EL PASO COUNTY PARKS DEPARTMENT | PARK PLANNING DIVISION

January 14, 2026

Subject: The Triple H Ranch Preliminary Plan (SP-25-004)

MATCH LINE SEE SHEET 11

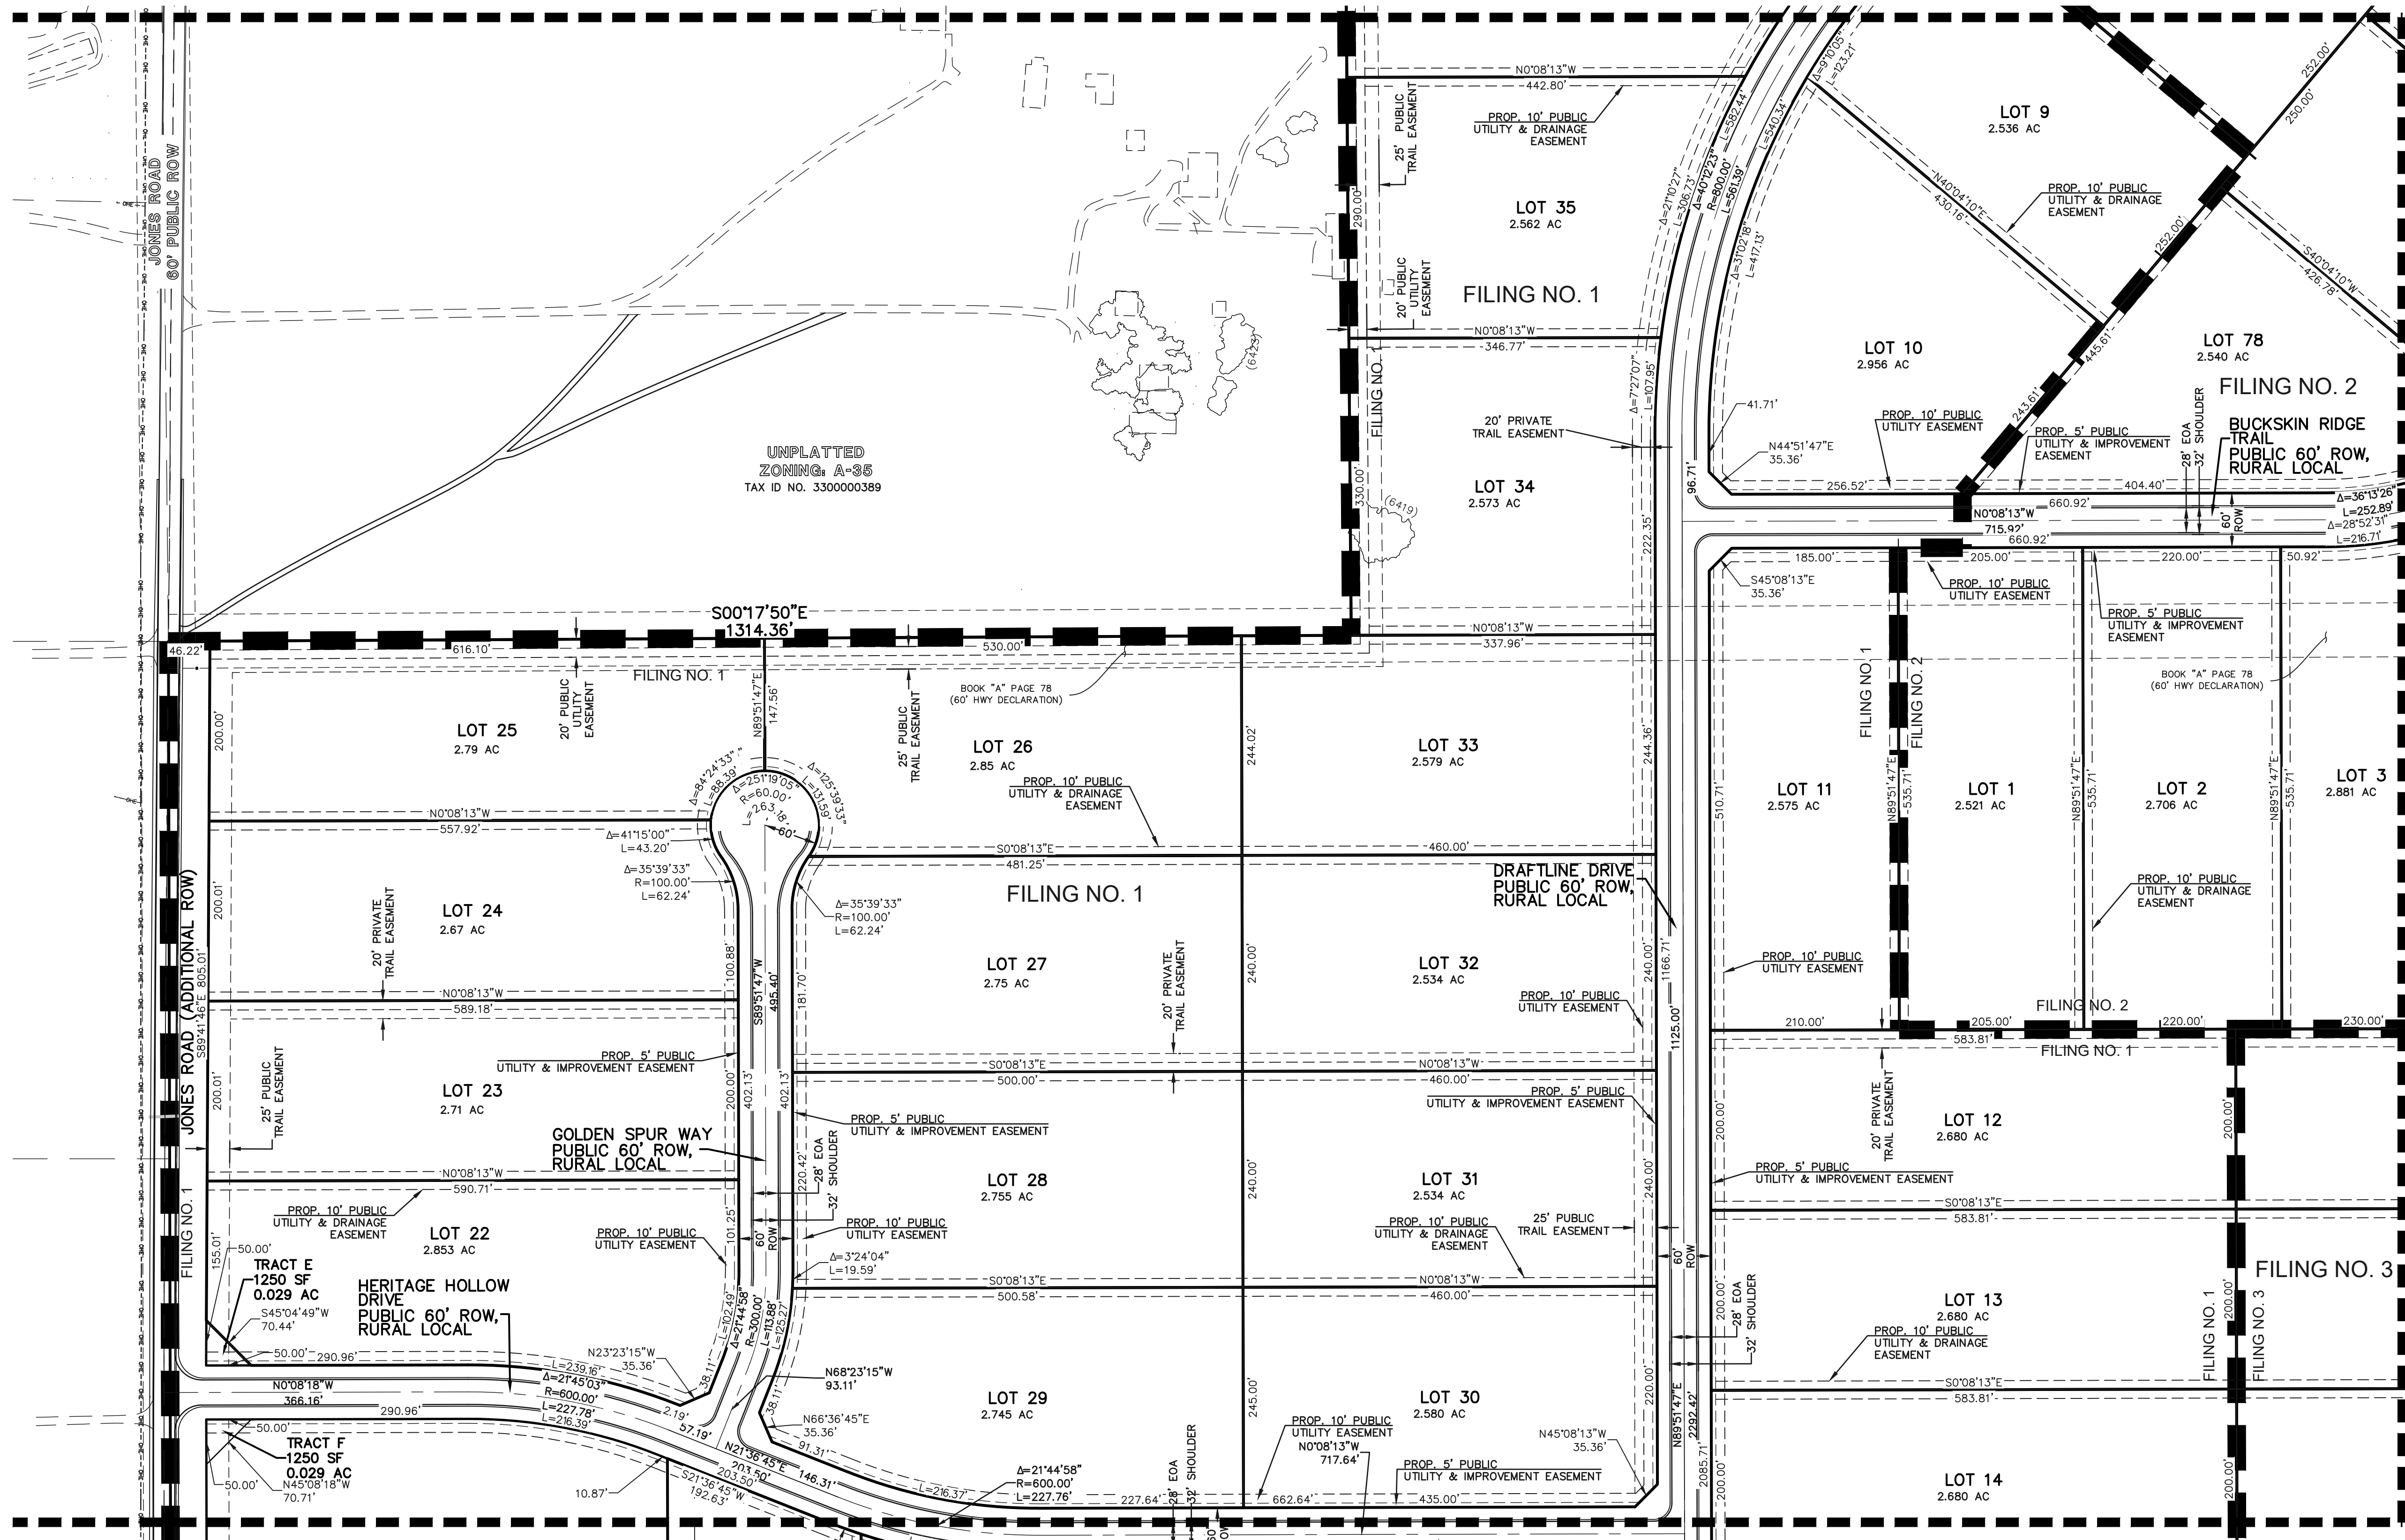
El Paso County Parks staff is pleased to see the applicant's willingness to provide open space tracts, two neighborhood park sites, and trail corridors. Upon review of the preliminary plan drawings, Parks staff noticed that the drawings do not clearly identify proposed county vs. non-county trails. Parks staff is requesting the applicant update and revise the preliminary plan to clearly delineate all trail easements and distinguish between county and non-county trails.

After reviewing the preliminary plan, staff met with the applicant to discuss the regional trail easement corridor along the southern boundary. Specifically, to discuss the alignment of the regional trail around an excluded parcel along Jones Road that would prevent a contiguous trail corridor. After discussion with the applicant, staff is recommending that two trail easements be secured as part of this application, with plat notes stating the County will only develop one alignment and relinquish the other. One easement will follow Jones Road and traverse the southwest corner of the project boundary, following the Parks Master Plan alignment. The second easement would include an alignment within the Triple H project boundary around the excluded parcel, generally along Harmony Hill Road, Appalossa Run Drive, Draftline Drive, and Heritage Hollow Road.

lieu of land dedication for regional park purposes in the amount of \$123,220. A Park Lands Agreement may be an acceptable alternative to required fees, provided the agreement is approved by the County prior to recording the future final plat(s). (2) Designate and provide to El Paso County 25-foot public trail easements along the southwestern boundary and the southern boundary of the Triple H Ranch Preliminary Plan along Jones Road, that allow for public access, as well as construction and maintenance by El Paso County for the Judge Orr Secondary Regional Trail, and the easements be shown, noted, and dedicated to the county via the forthcoming Final Plat(s) (3) Parks staff requests that the applicant designate and provide to El Paso County a 25-foot public trail easement following near Harmony Hill Road, Appaloosa Run Drive, Draftline Drive, and Heritage Hollow Road which are at the south end of the Triple H Ranch Preliminary Plan boundary. Staff recommends that El Paso County relinquish the trail easement if in the future it is no longer required and the master planned proposed trail can be obtained. (4) Parks staff is requesting the applicant update and revise the preliminary plan that clearly delineates all trail easements and explicitly distinguishes between County-maintained and non-County trails.
